DEVELOPMENT FACILITATION TEAM

Planning - Case Comments

Project Number: PR-2019-002639

Project Name: 200 Lomas Blvd NW

Figure 2: Existing Subdivision Showing 48 Lots

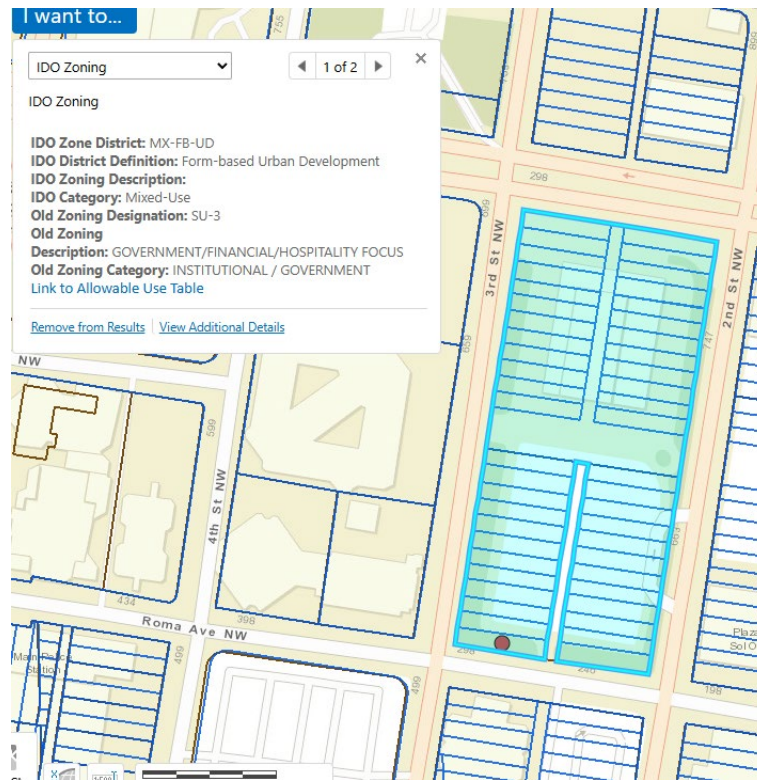
- **This is dependent on how the applicant will be associating an infrastructure List if one is required. Will it be associated with the plat or the Site Plan?**

Plat of
Lot 24-A, Block 4 & Lot 24-A, Block 5
Francisco Armijo y Otero Addition
Town of Albuquerque Grant, Projected
Section 17, Township 10 North, Range 3 East, N.M.P.M.
Albuquerque, Bernalillo County, New Mexico
August 2025

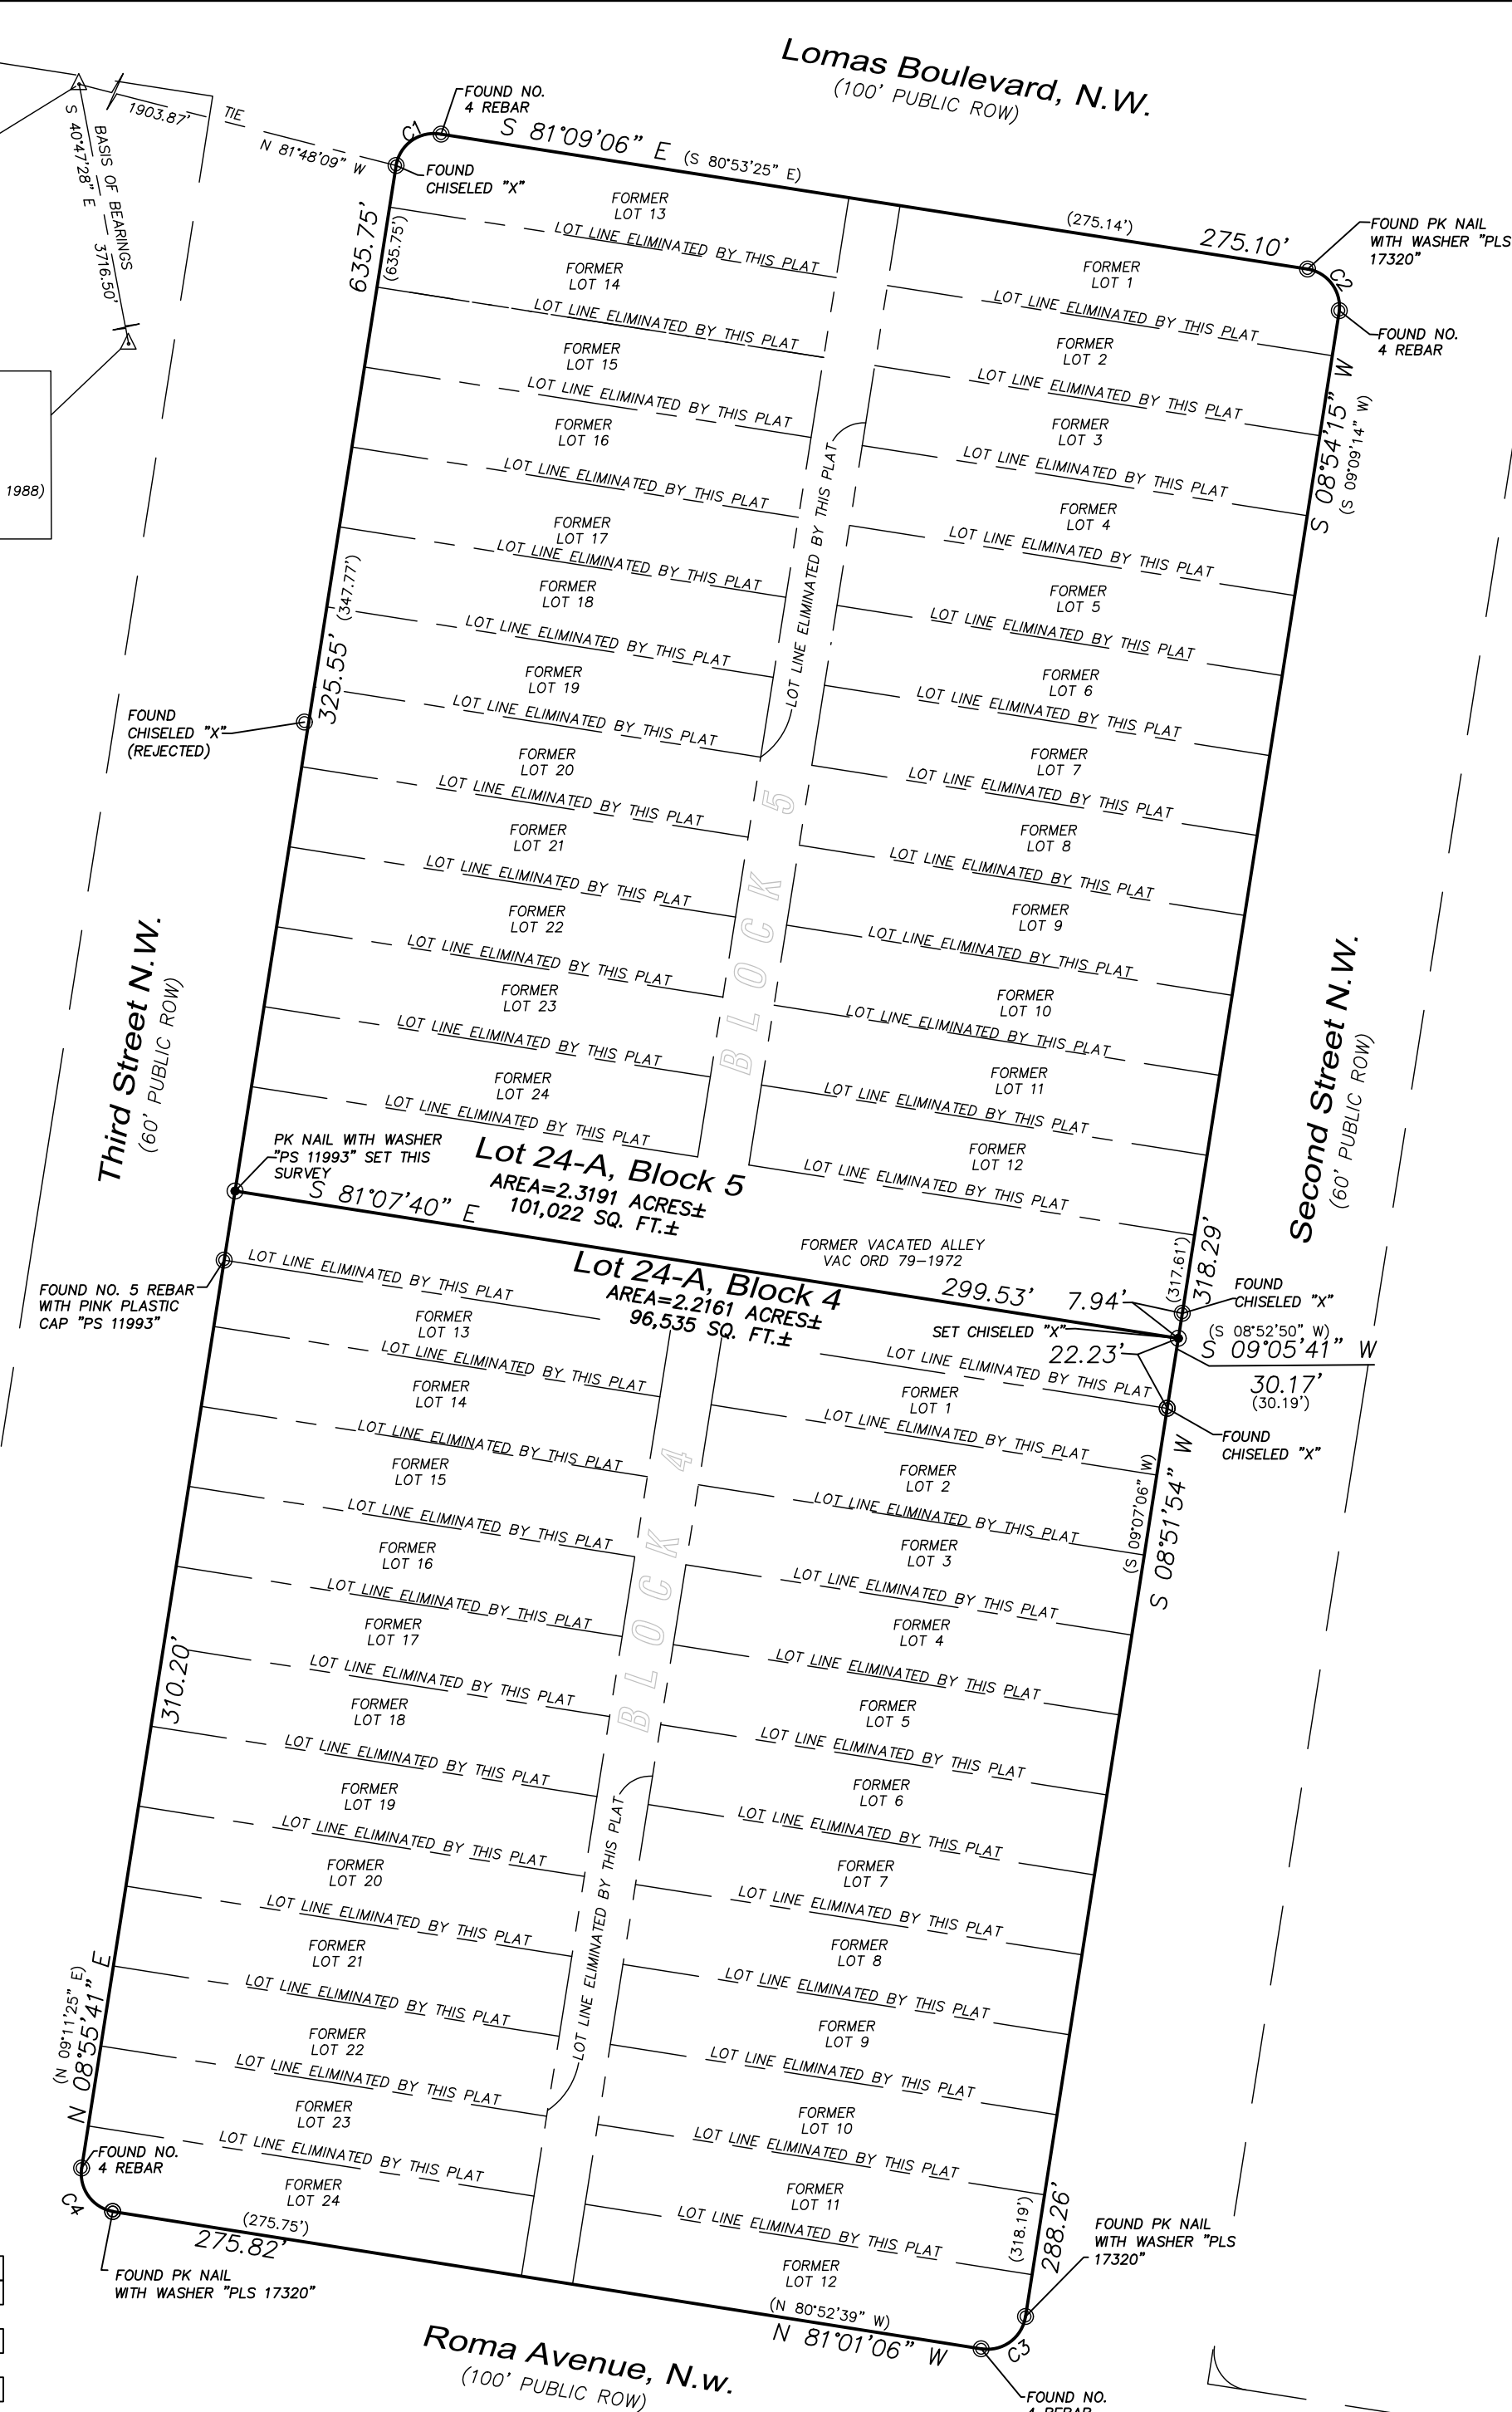
In this case, the property line that is being created cannot pass-through parking spaces.

- Add a 20' public drainage easement centered on the existing storm drain line to the plat.

1. Need to add the following note to the plat: "Existing public water and/or sanitary sewer infrastructure may not be constructed or sized to adequately serve potential future development. Improvement or upsizing of existing public infrastructure may be required as a condition of future development approval."
